WEST SUSSEX COUNTY COUNCIL CONSULTATION

TO:	Arun District Council FAO: Maria Tomalova
FROM:	WSCC - Highways Authority
DATE:	9 December 2020
LOCATION:	3 Glencathara Road Bognor Regis PO21 2SF
SUBJECT:	BR/276/20/DOC Approval of details reserved by condition imposed under ref BR/32/16/PL relating to Condition No 3 - new boundary treatments, 6 - pedestrian visibility spays and 7 - covered & secure cycle parking.
DATE OF SITE VISIT:	n/
RECOMMENDATION:	More Information
S106 CONTRIBUTION TOTAL:	n/a

The proposal is for the Discharge of Conditions 3 (Boundary Treatment), 6 (Pedestrian Visibility), 7 (Cycle Storage) of permitted planning application BR/32/16.

DRAWING TITLE
Conditions 3 & 6

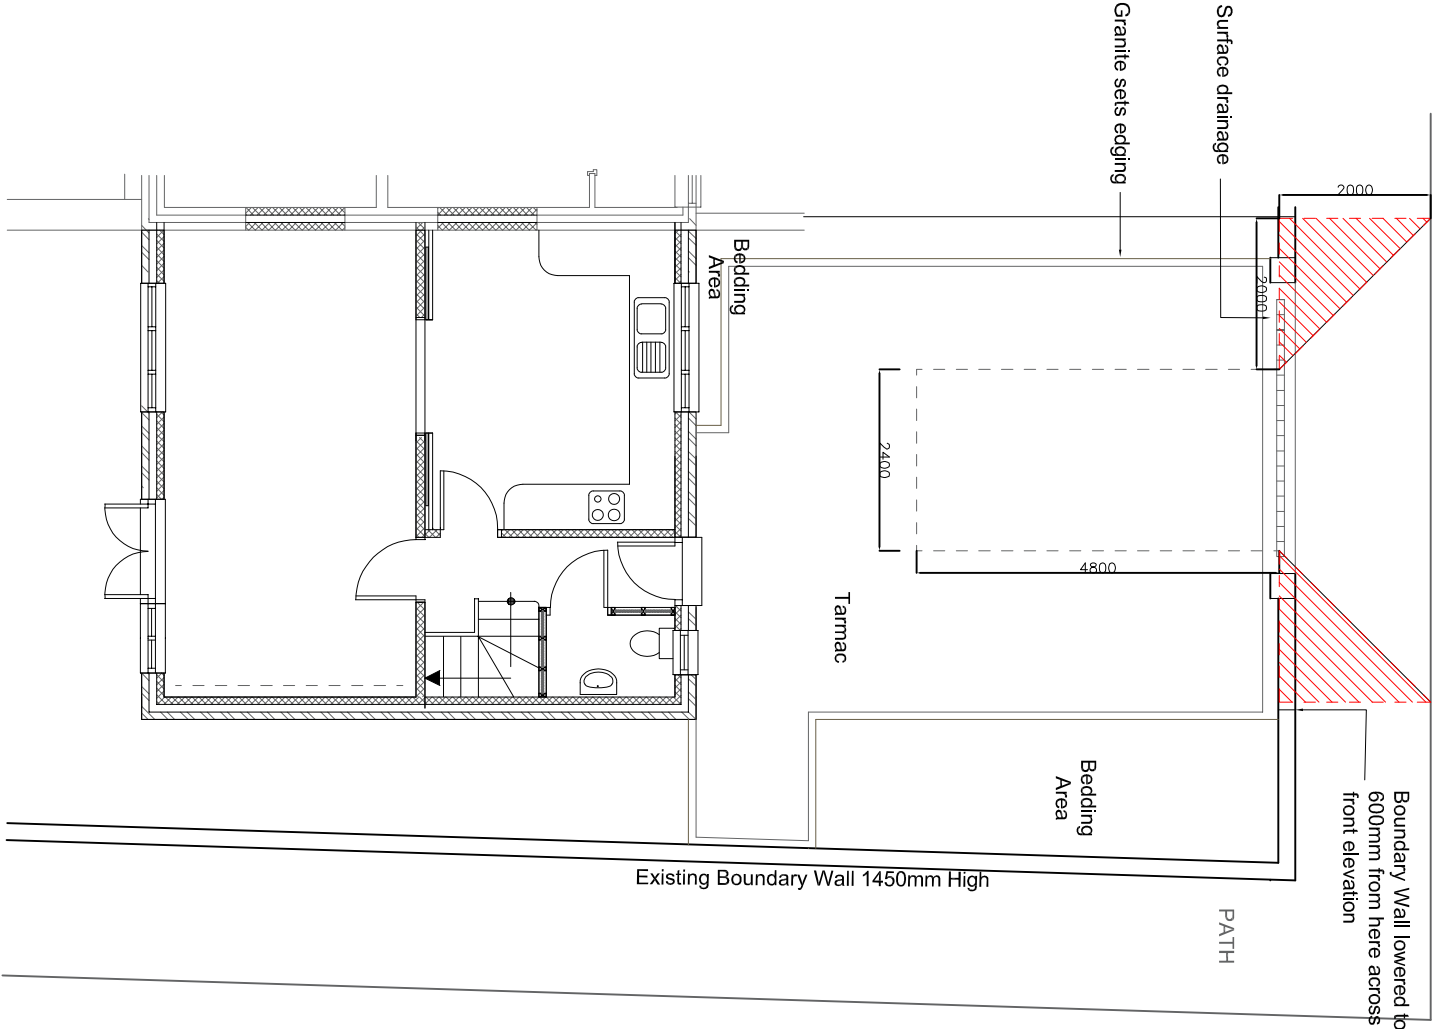
Condition 6, Pedestrian Visibility – The LHA advises that pedestrian visibility must be within land under the applications control and clear of any obstructions, this is to include the driving line of any car using the access. Please amended these details to show the above advise.

Timber clad bike shed

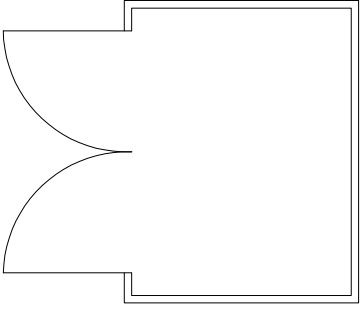
Condition 7, Cycle Storage/Parking – The applicant has provided such details in accordance with WSCC and MfS guidance for covered and lockable cycle storage facilities and is to be located within a garden shed.
